CITY OF MERCER ISLAND

RE: Request for Information #1 for File No. CAO22-003 & SUB21-008 – Koneru Short Plat
6610 East Mercer Way, Mercer Island, WA 98040; King County Tax Parcel # 302405-9153

**SHEET C0.1**

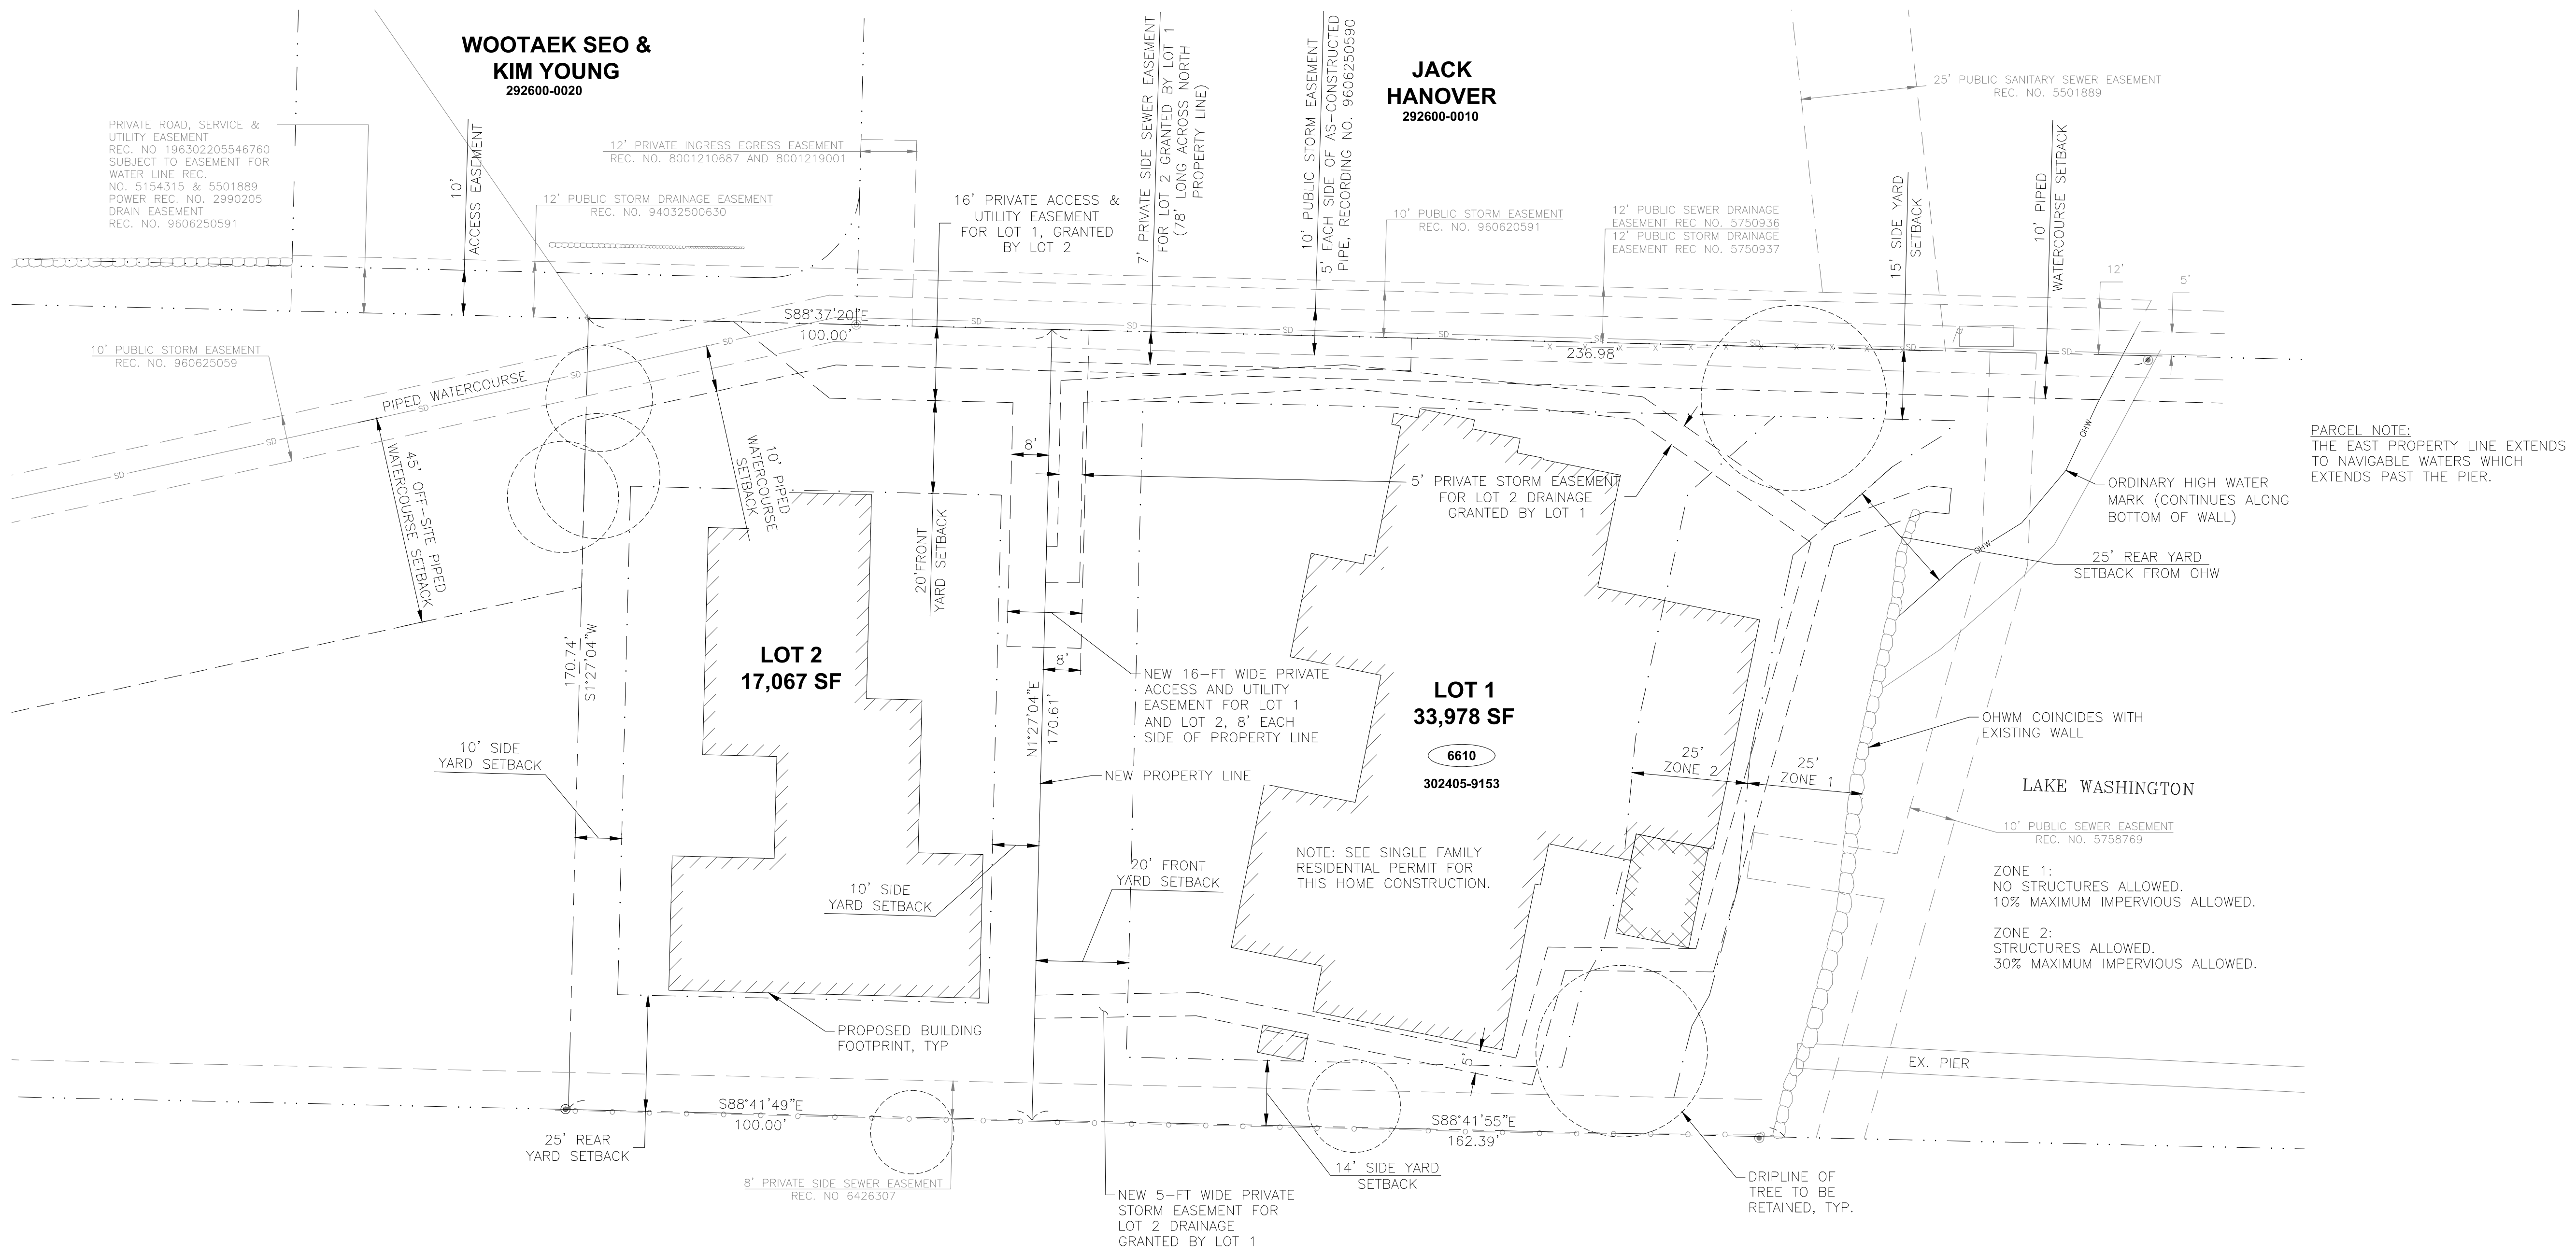
- j. Revise the following typos:
 - i. Sheet C0.2: legal description misspells "said" in the second paragraph
 - ii. Sheet C1.0: piped watercourse note misspells "setback"

SHEET **C1.0**

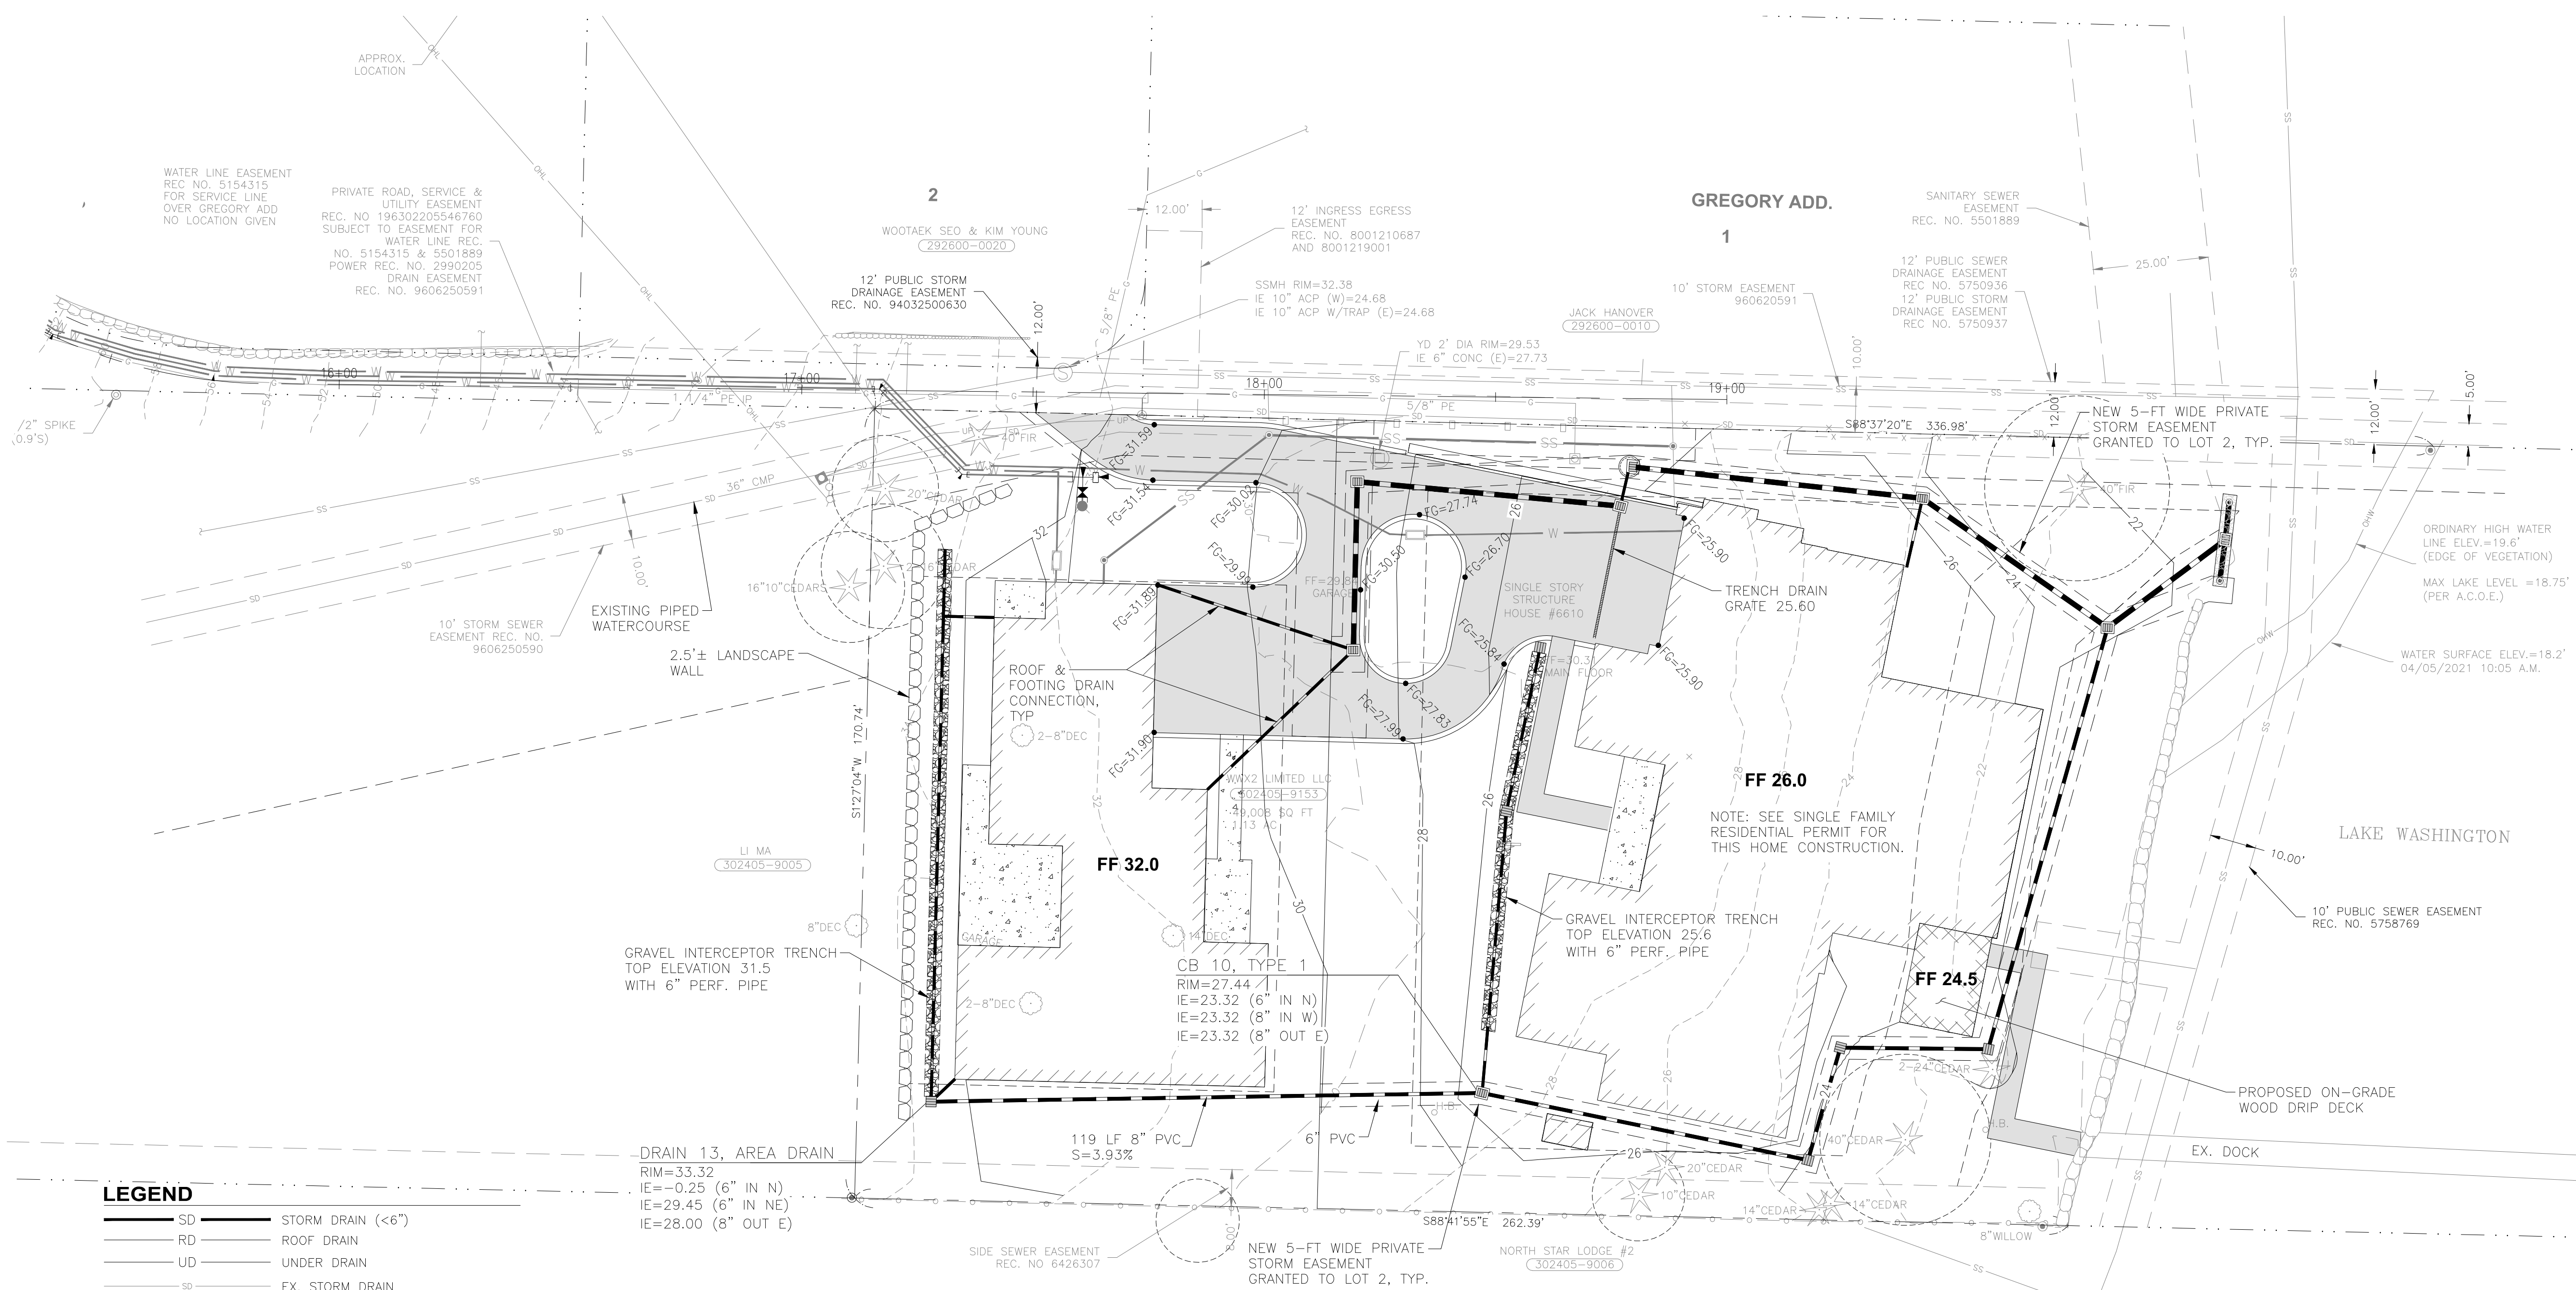
- d. Topographic map: for any existing buildings, the map shall show the finished floor elevations of each floor of the building.
 - e. Note the Ordinary High Water Mark (OHWM) on Sheet C1.0. Refer to MICC 19.16 definition of "Ordinary High Water Mark."

R-15 zone: The net lot area shall be at least 15,000 square feet. Lot width shall be at least 90 feet and lot depth shall be at least 80 feet. Maximum allowed GFA in the R-15 zone is 12,000sf or 40% of the lot area, whichever is less.
2. Piped watercourse:
- a. Typo on Sheet C1.0: the note regarding the piped watercourse misspells "setback."
 - b. For the portion of the piped watercourse off-site, revise the setback to be the standard 45 feet from the centerline of the piped watercourse. The setback reduction applies to the subject site only.
 - c. Pursuant to MICC 19.07.180(C)(6)(d), lots with a width greater than 50 feet can reduce the piped watercourse setback to 10 feet when daylighting is determined by a qualified

professional to result in one or more of the 4 outcomes listed under 19.07.180(C)(6)(d)(i-v). Please clearly illustrate and label the reduced 10 foot piped watercourse setback on Lot 1 and Lot 2.

- d. Clearly illustrate and label the piped watercourse centerline. Piped watercourse is noted but it is unclear where it is located as there are multiple lines that look similar that represent existing easements. Please use a different line to represent the piped watercourse and add an arrow.

- c. Note recording numbers and width for all existing easements.
 - d. Note proposed easement widths.
 - e. Revise the 10' watercourse setback to "10' piped watercourse setback."

**C3.0**

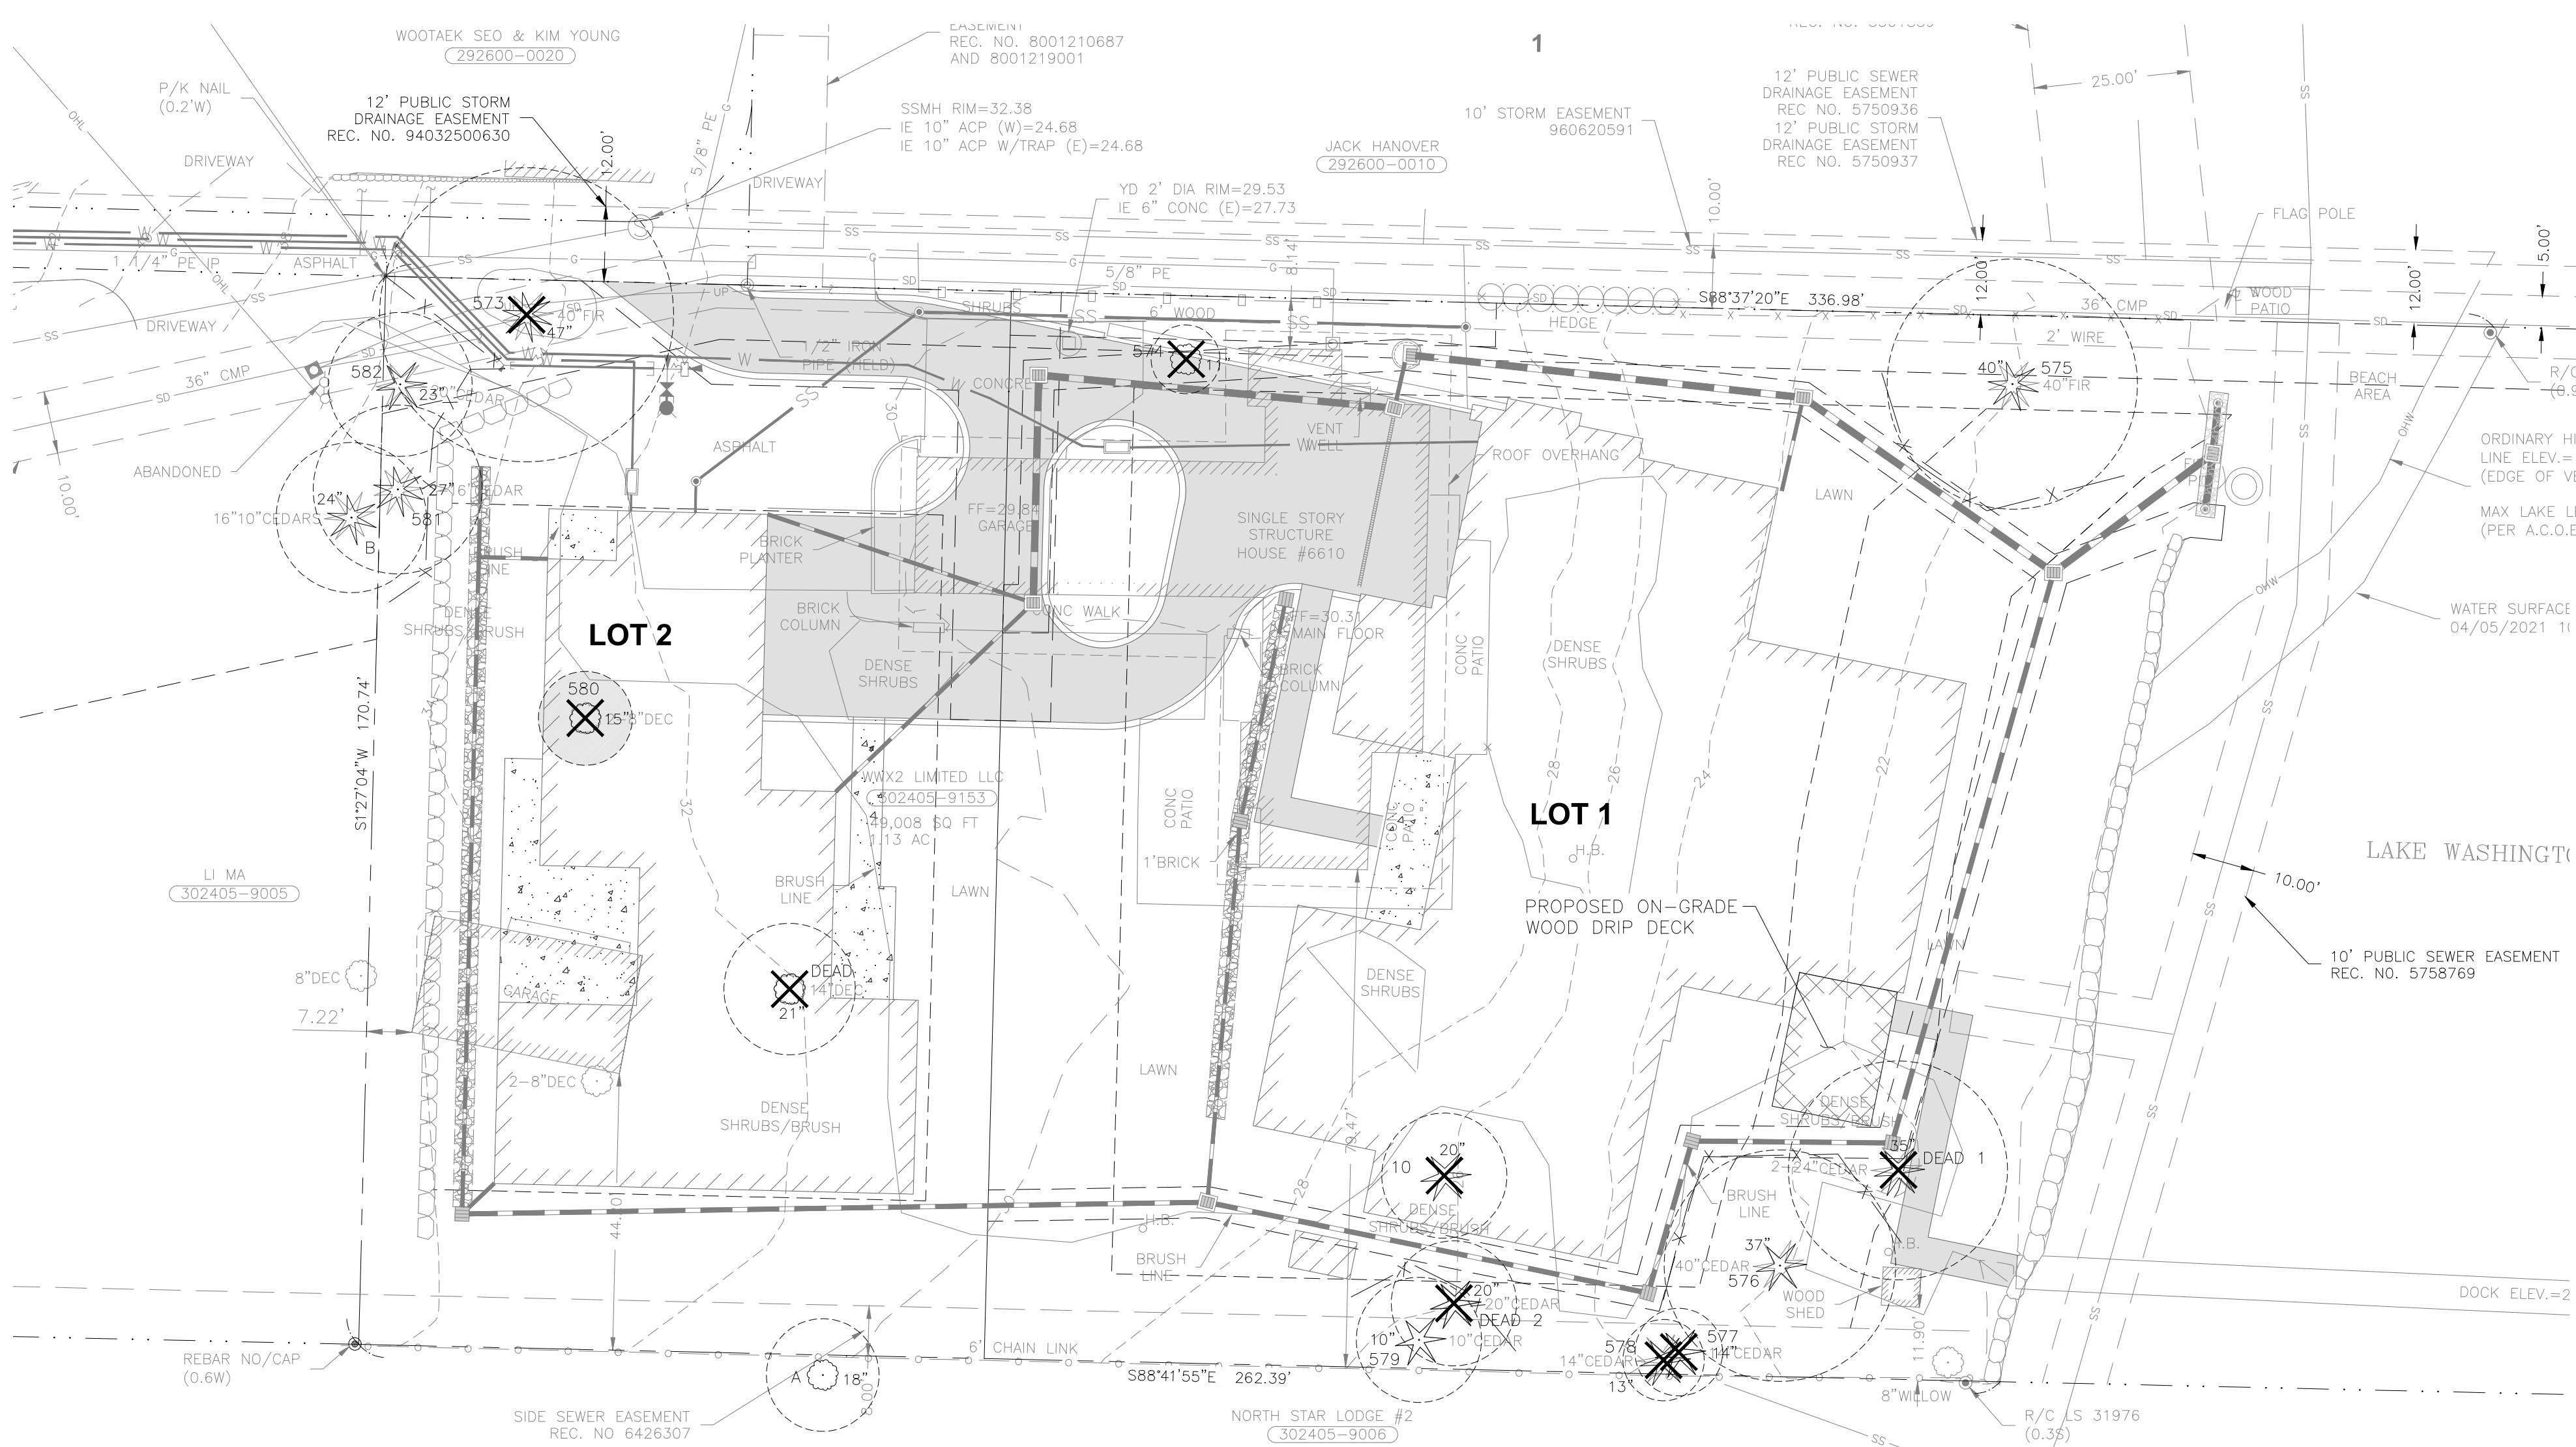
4. (For Civil and Arborist) A tree protection plan with all Civil information must be created. No tree protection is shown on C3.0. The retaining wall, trench, and other utilities to be moved outside saved trees driplines/limits of allowable disturbance. The SD is shown within 9' of exceptional tree 14. Update tree protection plan with tree protection chain link fence and all the following items in this checklist. Exceptional trees must be retained according to 19.10.060.3. and protected under 19.10.080.
https://www.mercerisland.gov/sites/default/files/fileattachments/community_planning_amp_development/page/21988/treessubmittalchecklist.pdf
